City of Albuquerque

May 13, 1994

RE: DRAINAGE PLAN FOR AN ADDITION TO 708 MARQUETTE NW (J14-D106)
ENGINEER'S STAMP DATED 4/13/94.

Figure 2 - Developed Site Plan (Plate 3)

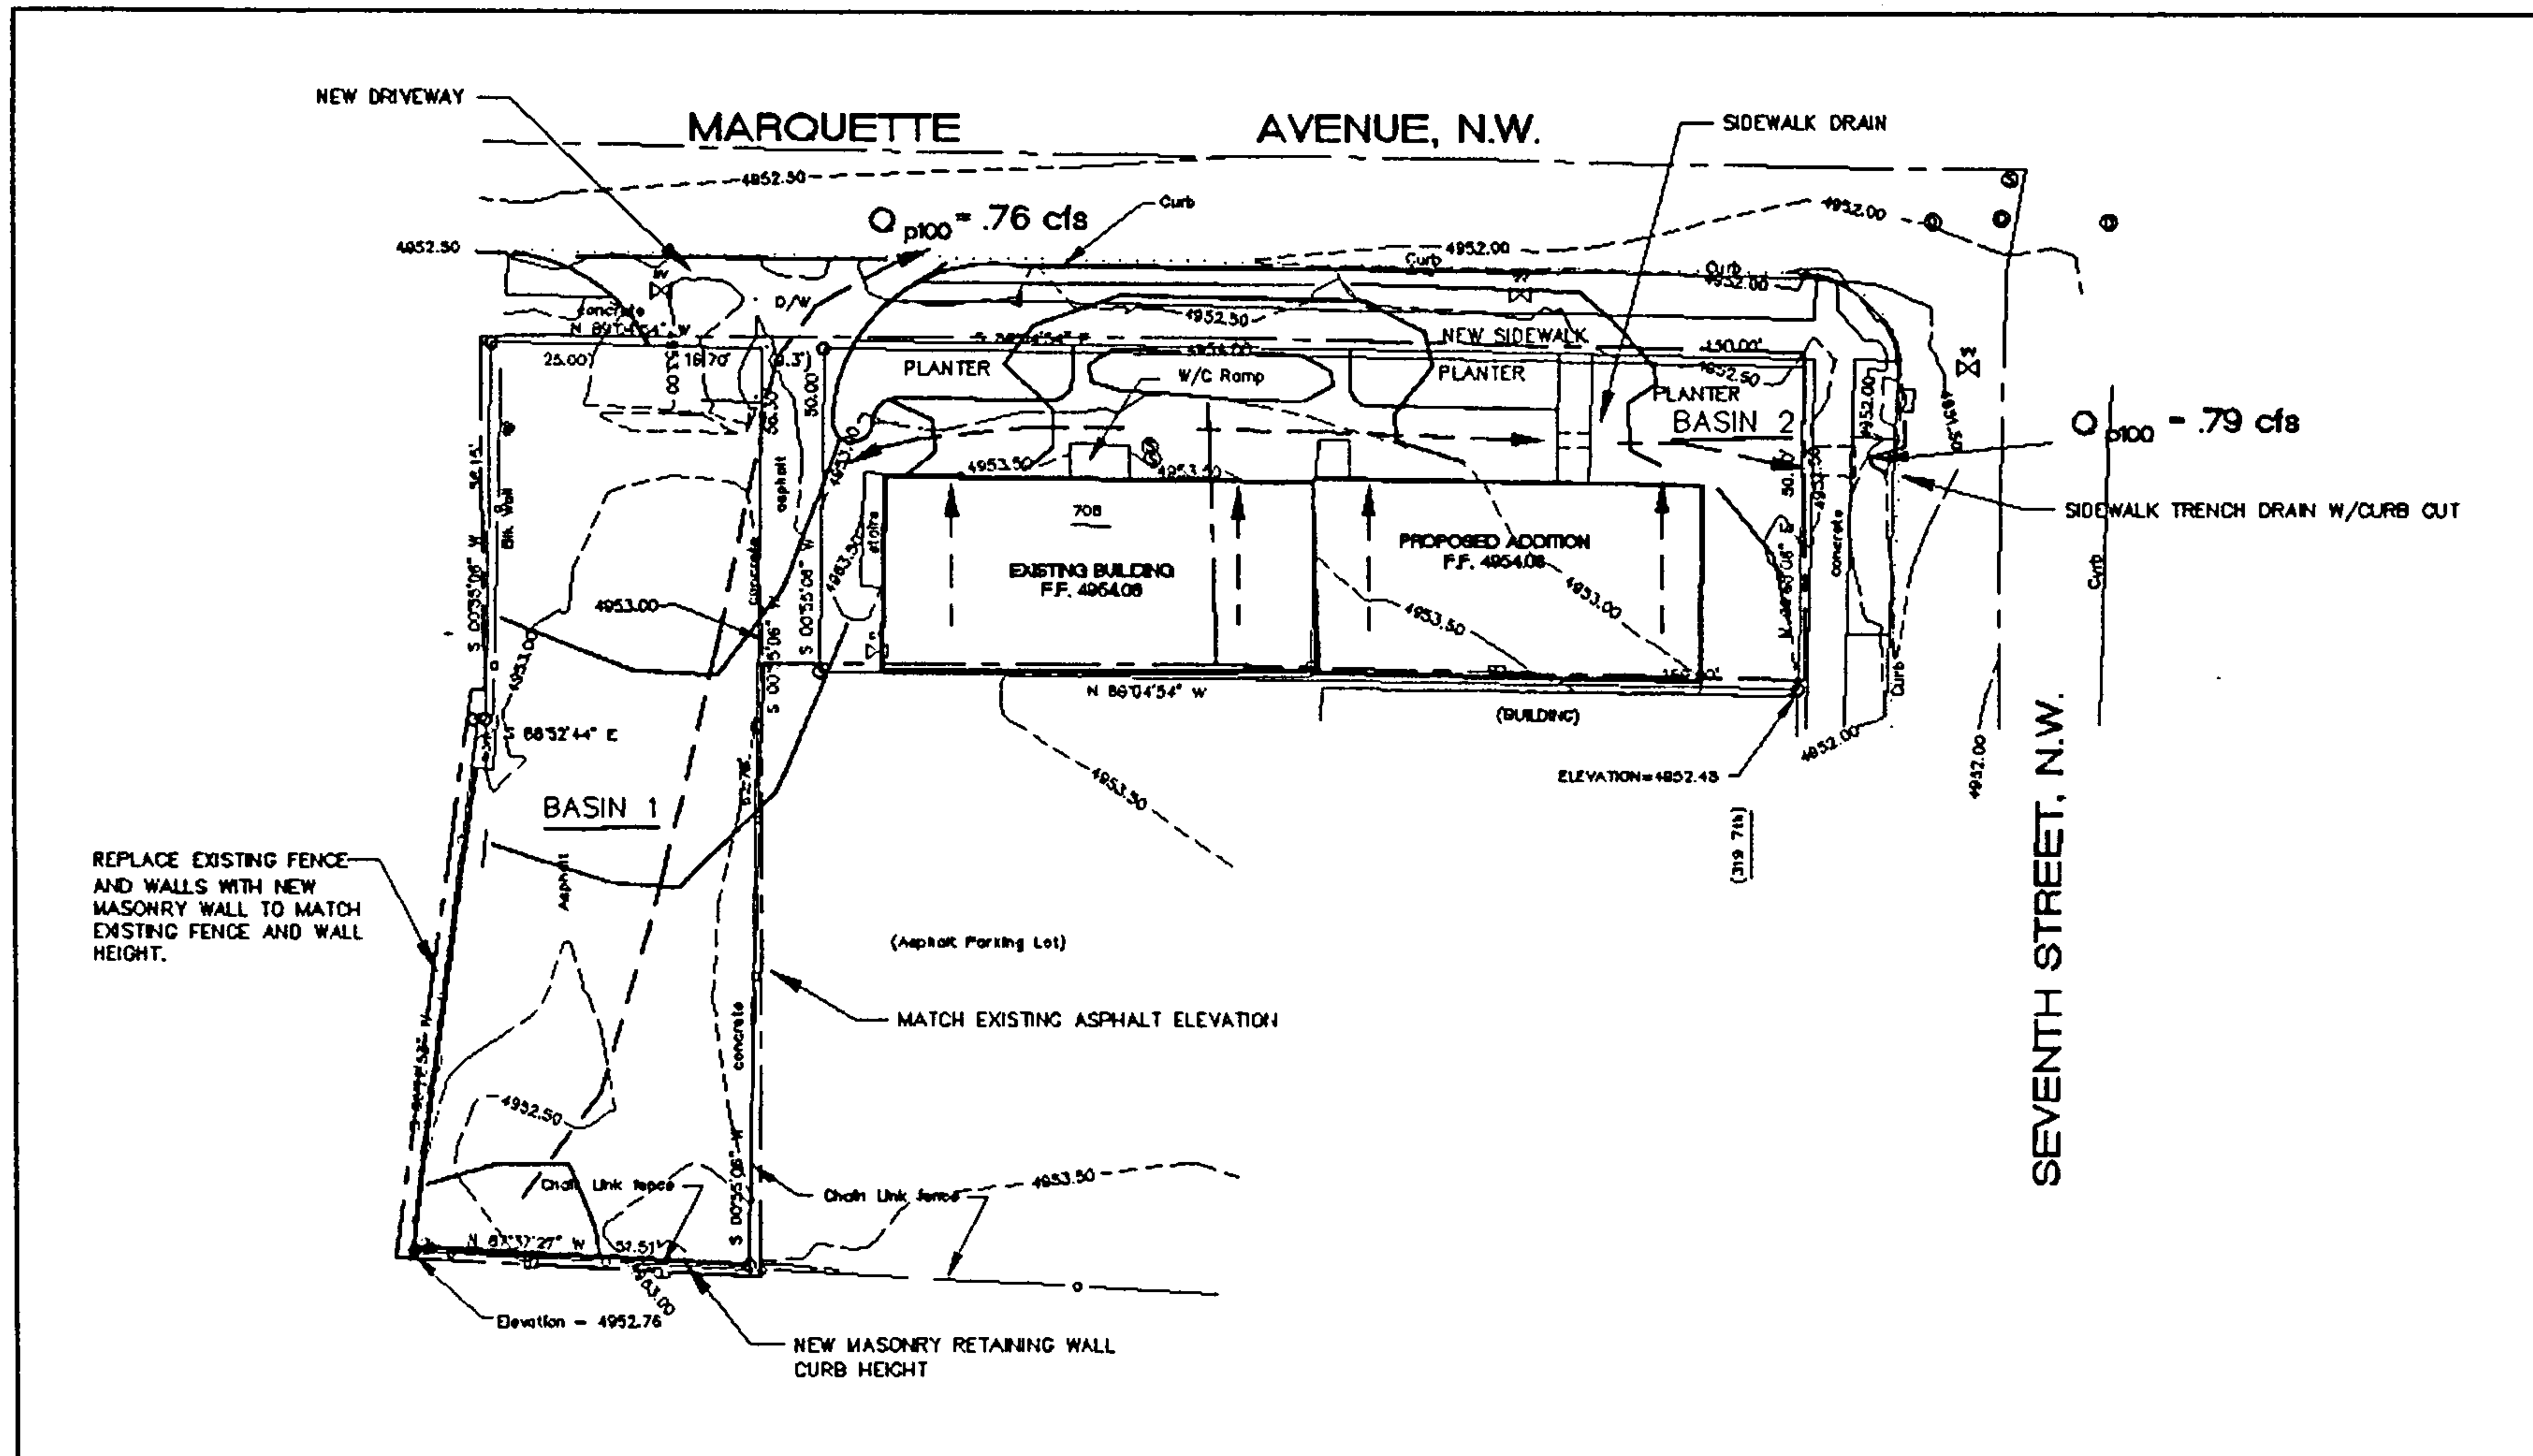
2. top of curb and flowline elevations on Marquette & Seventh St.
3. Your report identifies that you have a total of .689 cfs existing and .634 cfs proposed flow rates. The plan drawing indicates .76 cfs from basin 1 & .79 cfs from basin 2. I am confused to the difference in the quantities. Pre-design indicates that you are limited to the existing flow rate.

4. The S.O. 19 format for the proposed sidewalk culvert must be included on the plan drawing. The six notes and the sign-off block. You must also identify the City of Albuquerque Spec. No. for the sidewalk culvert (attached). This information must be on the plan drawing. Two copies of plan with the resubmittal.

5. Replat or paper easement for cross lot line drainage.
6. Please be advised that no developed run-off is allowed over and across a public sidewalk. Either a sidewalk culvert or a drivepad must be used.
